A1 Birtley to Coal House

Scheme Number: TR010031

Change Request

A1 Birtley to Coal House (TR010031) – Material Change request

KINGSWAY VIADUCT (JUNCTION 67)
PROPOSED CROSS SECTION B-B
SCALE 1:50

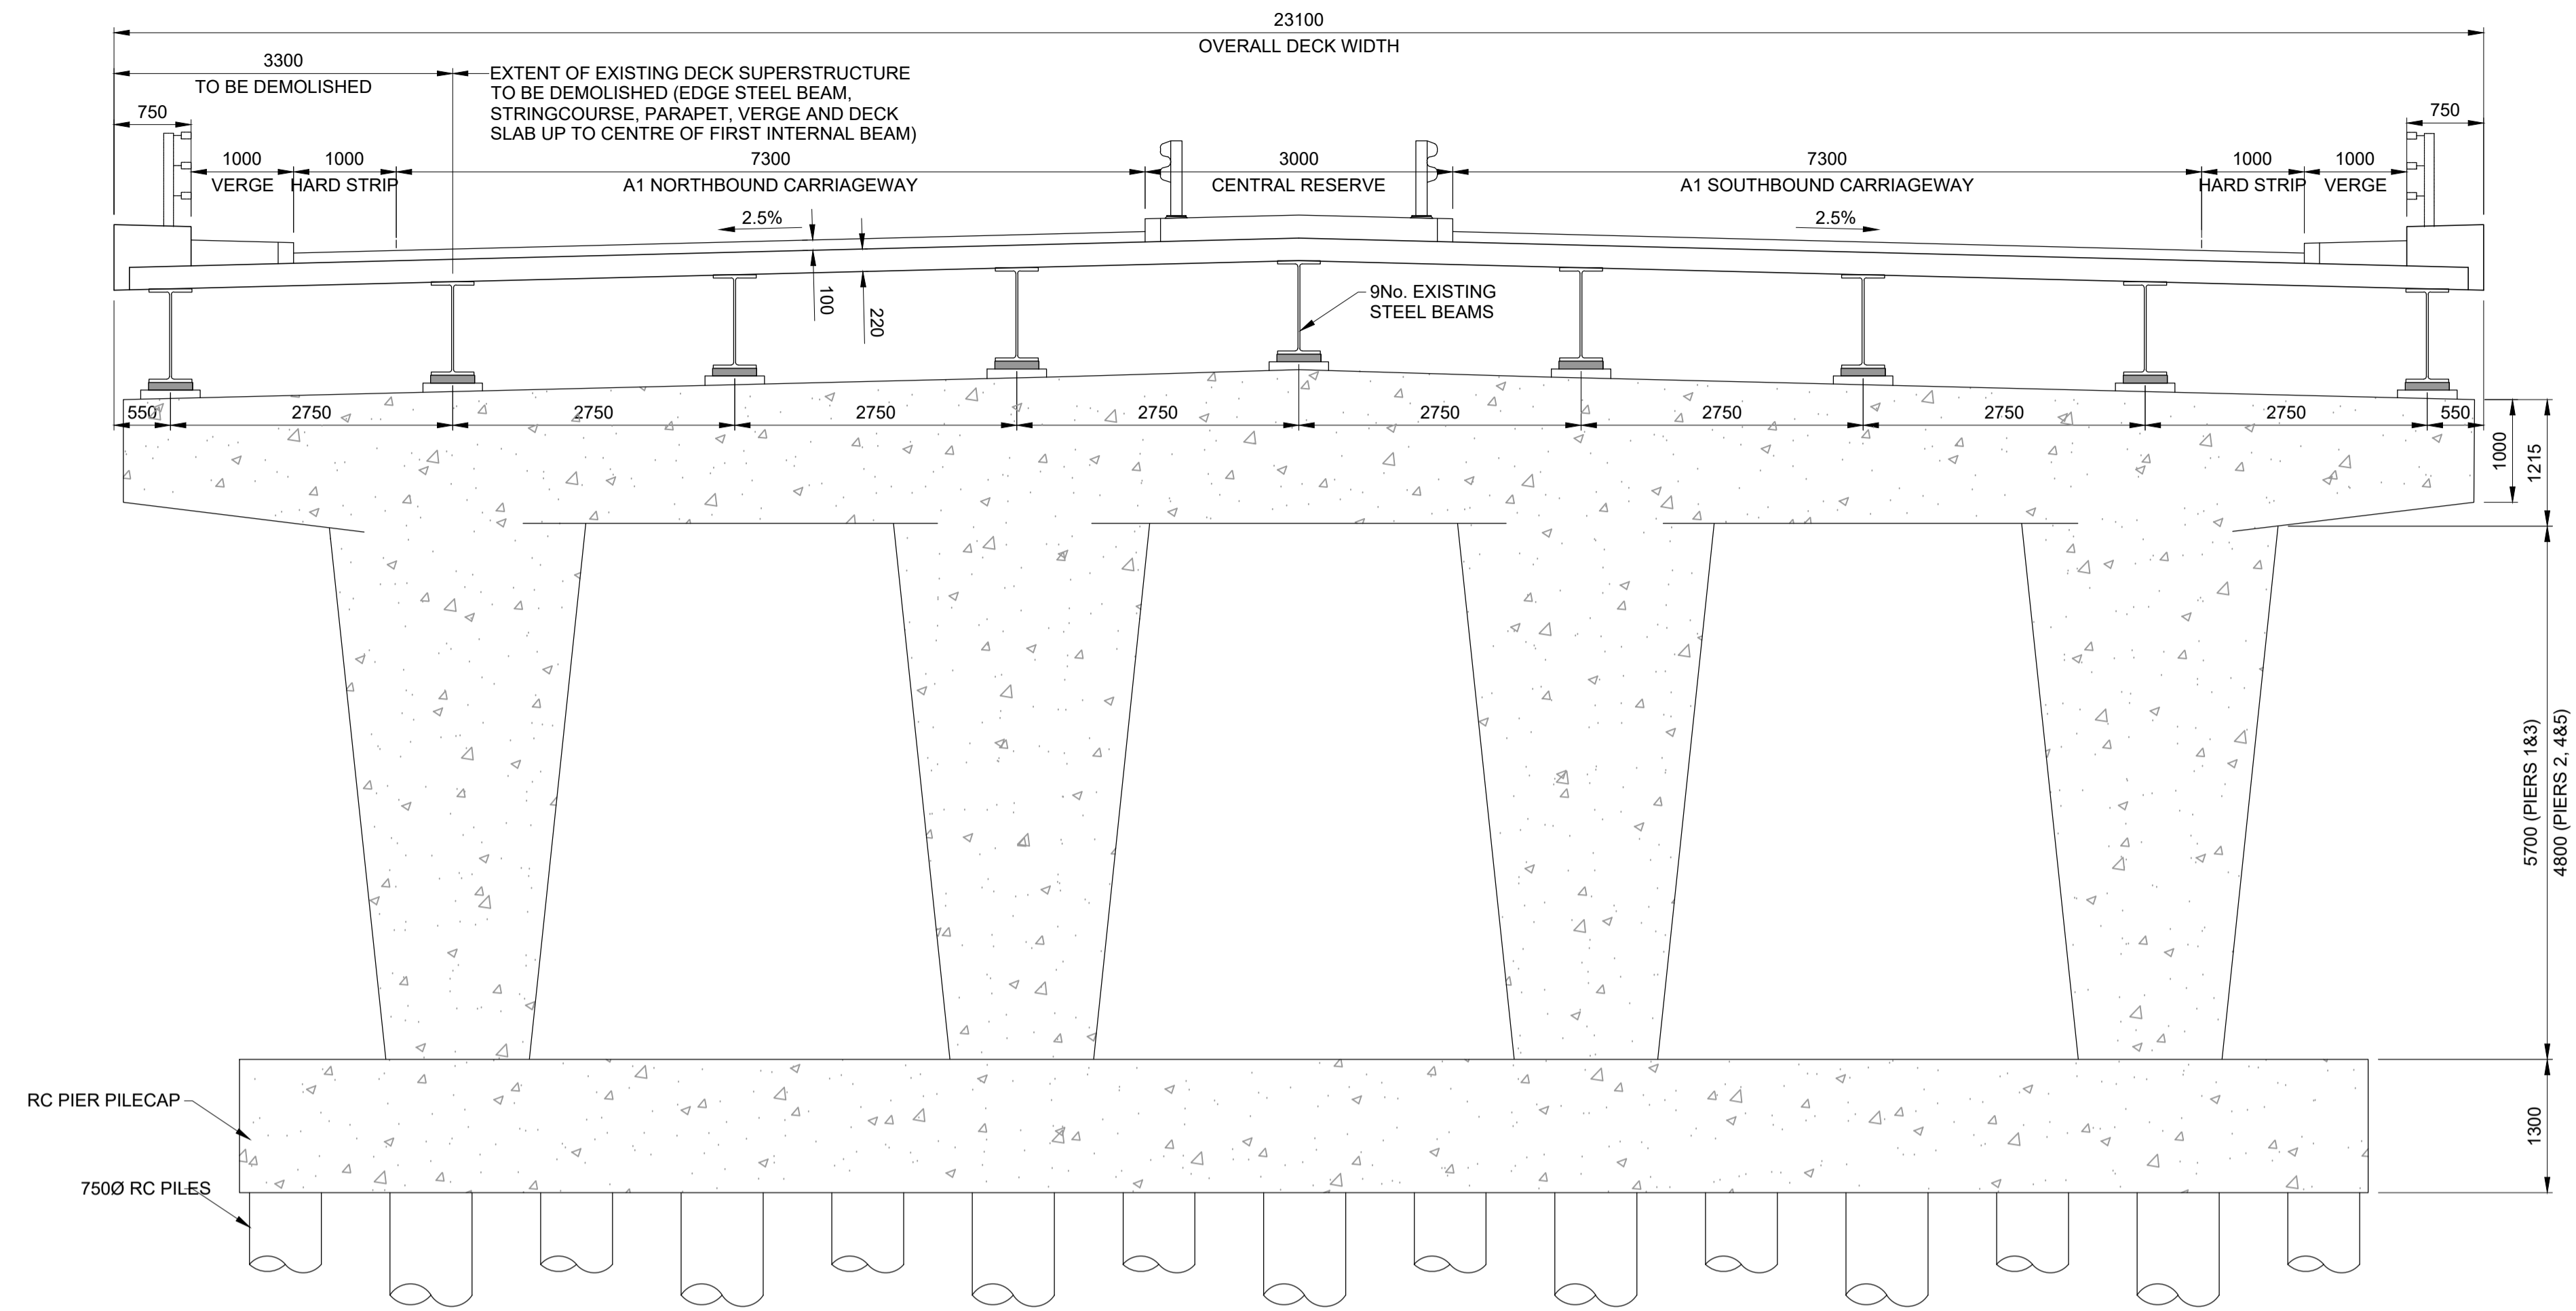
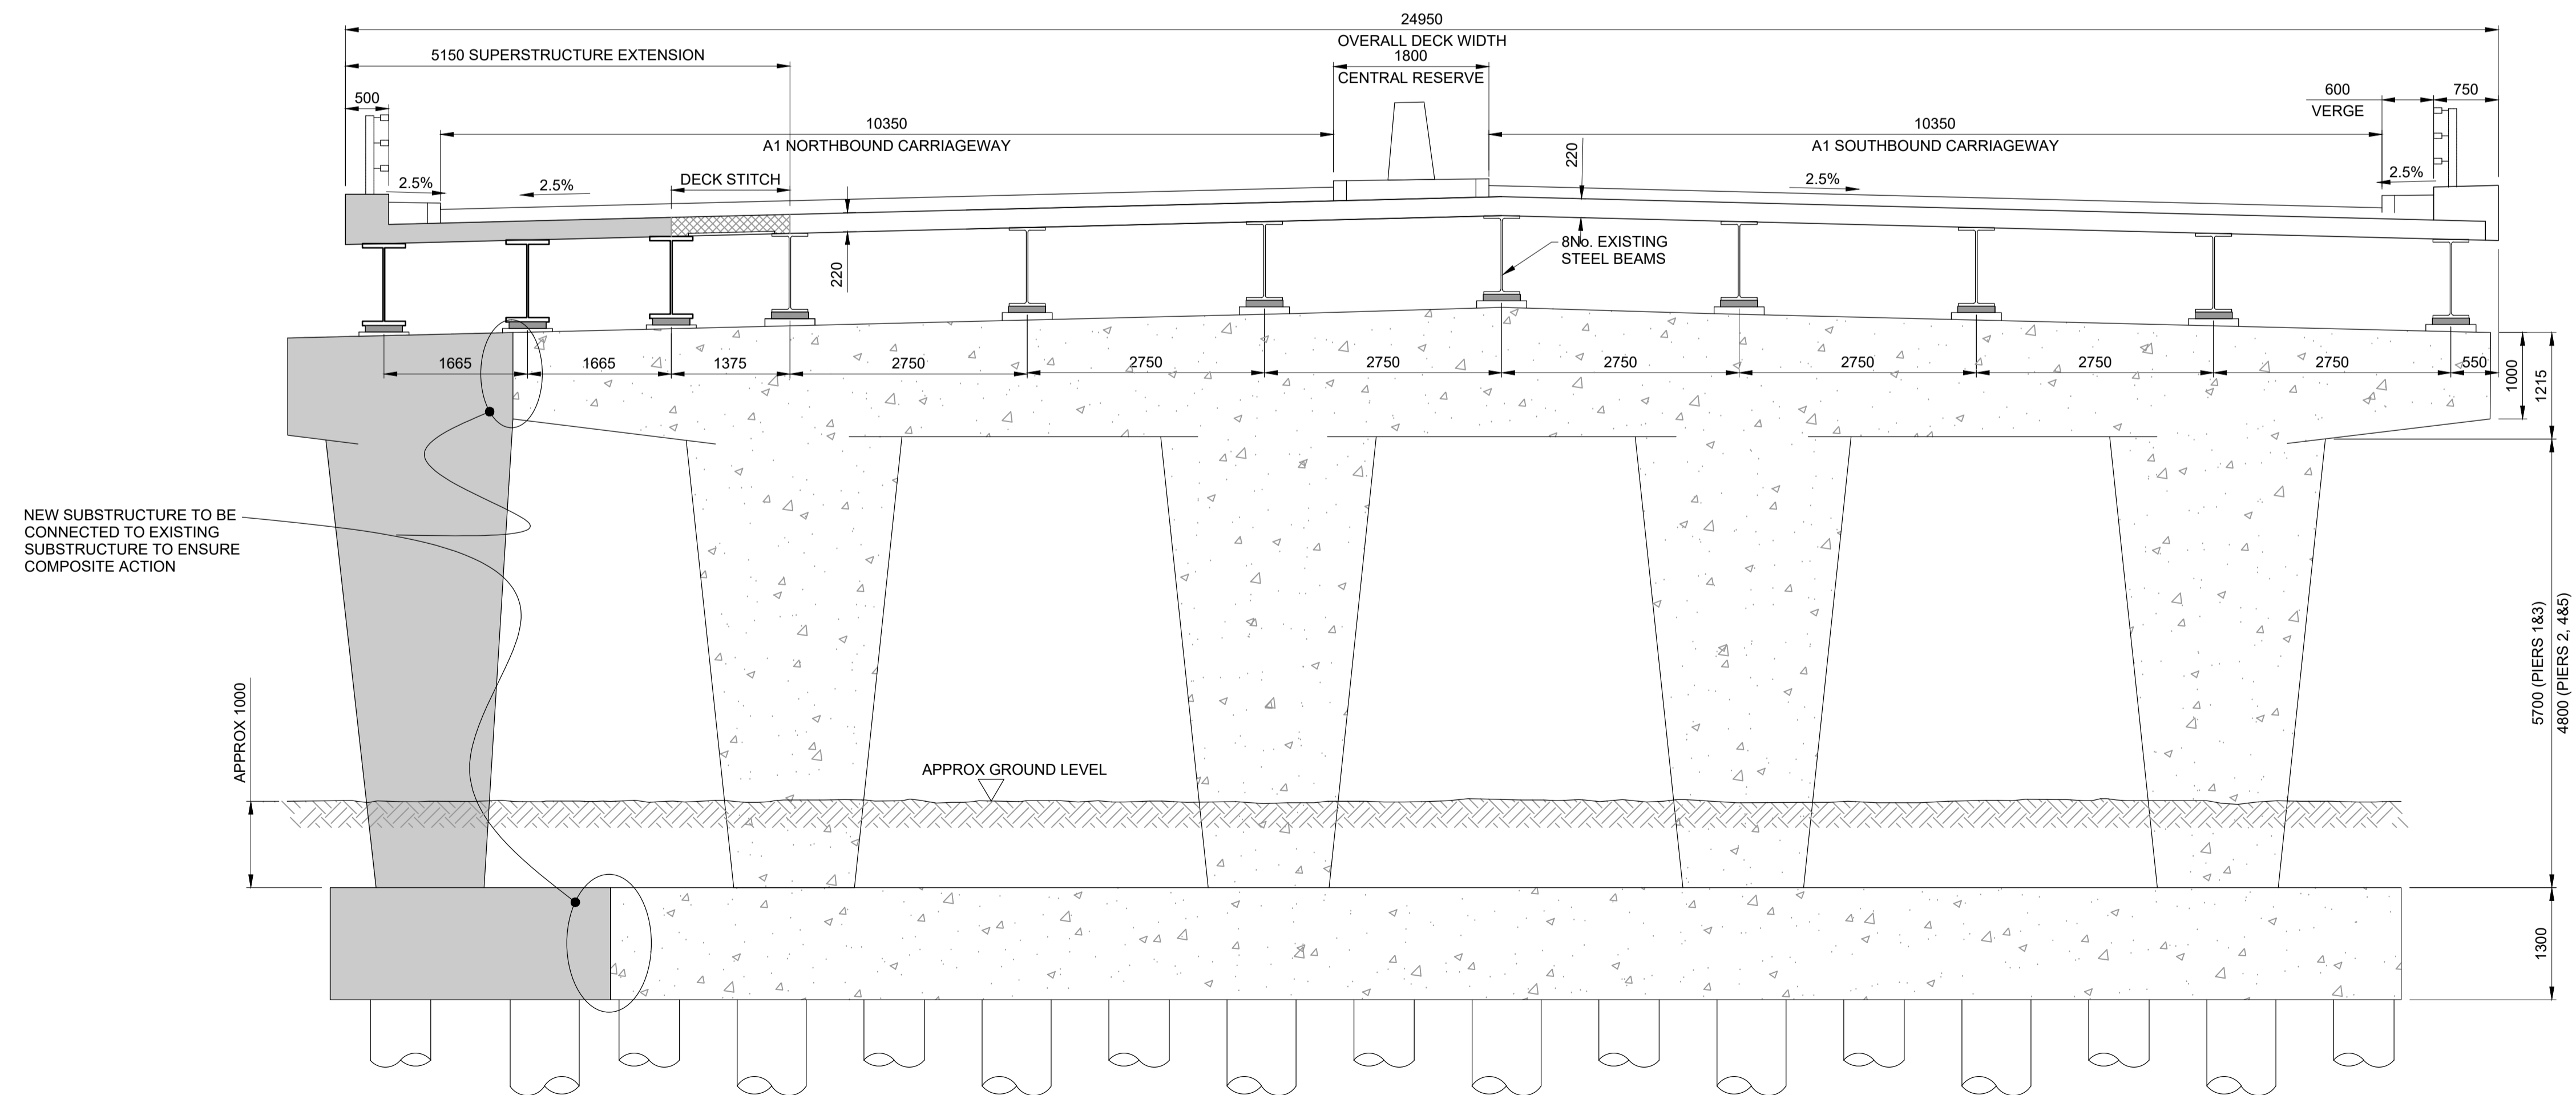
- **Change 2** - Providing flexibility as to the formation and the road layout of the Scheme to enable narrower lanes to be provided between the existing narrow lanes north of junction 67 (Coal House) and approximately chainage 11150 over Kingsway Viaduct at junction 67. The current Scheme proposes full width lanes. The new proposal is to allow narrower lanes extending over approximately 750m of the length of the Scheme to be introduced.

The Applicant proposes to amend the Application to include narrower lanes from land north of junction 67 (Coal House) and up to Kingsway Viaduct (at approximate chainage 11150) for a length of approximately 750m. This is a change from the current Application which seeks powers to provide full width lanes through the entire length of the Scheme. Applying this narrower cross section would reduce the structural widening at Kingsway Viaduct by approximately 5m (2.1m compared to 7m in the Application currently). It may also be necessary to amend the existing Traffic Regulation Order No. 1013 The A1 Trunk Road (Gateshead/Newcastle Western Bypass) (Width Restrictions) Order 2016 (TRO), which prohibits heavy goods vehicles from the offside lane and extend this to the south into the Scheme extents.

Details of the proposed design change and the benefits are provided in Chapter 2 of the *Summary of Proposed Changes to the Application January 2020* [AS-009]. The narrower lanes are also shown on the Structures Engineering Drawings and Sections (see Sheet No.14 and 15, [REP2-042] Revision 2a submitted for Deadline 4).
